Application Number SSD-77608714-Mod-2

Modification Increase building height and other external modifications

Location 1 Darling Point Road, Edgecliff (formerly 136-148 New South Head Road)

Figure 3 Approved vs Proposed Northern and Eastern Carpark Façade

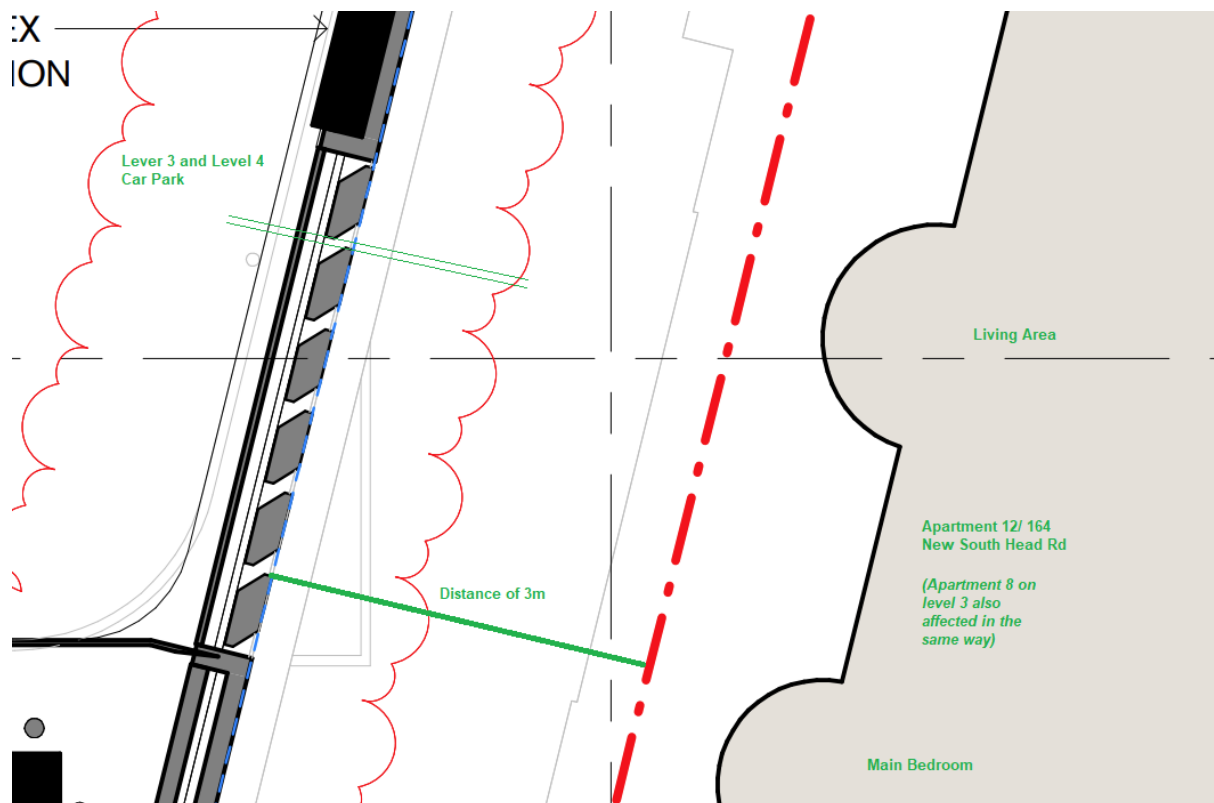
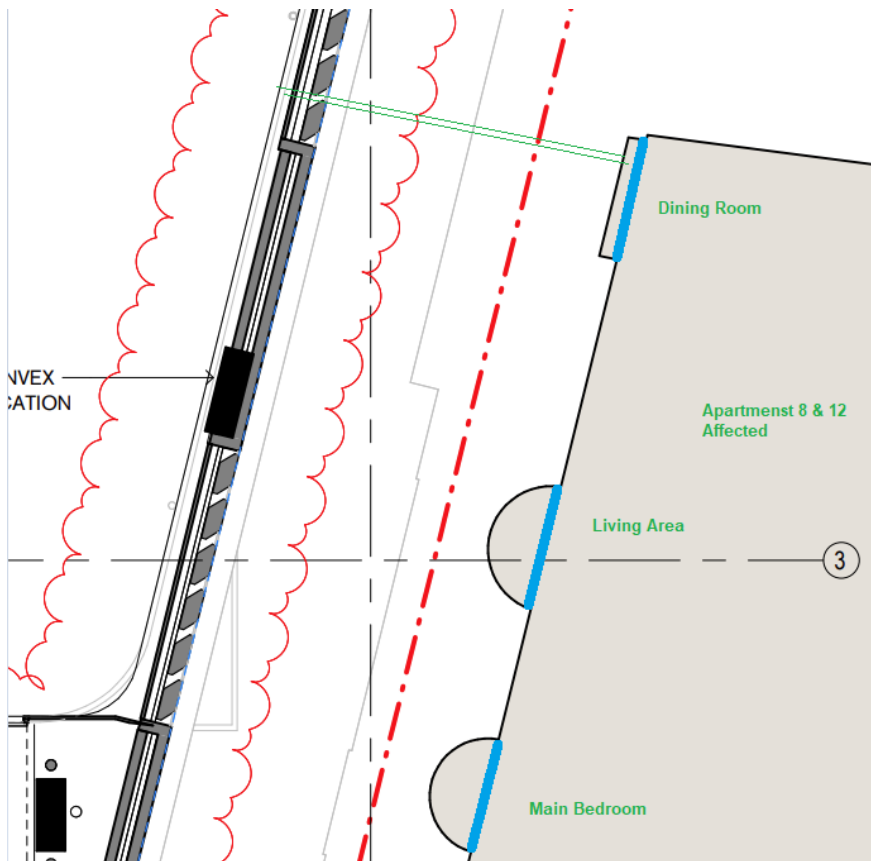
- North elevation – The carpark façade is changed from articulated slivered brick to coloured pre-cast concrete panels, and the base is amended from masonry to precast concrete.

- East elevation – The horizontal brick is changed to precast concrete. The frequency of the vertical gaps is decreased, and the base is amended from masonry to precast concrete.

The materiality of the podium level façade treatments has changed to substantially more concrete over brickwork. This is particularly evident on the north elevation, where brick has been replaced for precast concrete, and precast concrete replaced by mass concrete. This further reduces the texture, warmth and definition on the façade and the characteristics that made it more sensitive to the heritage item.

Generally, across the board, changes in material from brick to concrete, or brick to aluminium, is a reduction in the warmth and texture that was originally proposed. The original proposal is more sensitive to the character of the heritage item.

The approved scheme adopted a bladed brick expression to both the eastern and northern frontages of the above ground car park to mitigate the visual impact to the neighbouring properties.

The change in materials and reduction in articulation, results in a poorer outcome when viewed from the neighbouring properties. The approved articulation and design detail is important as the outlook from several properties to the east and north (which include views to the city skyline and district views) will be replaced entirely with views of the podium. Refer to the image below from the Visual Impact Assessment submitted with the original SSD application.

The reduction to the articulation and the quality of the materials should not be supported.
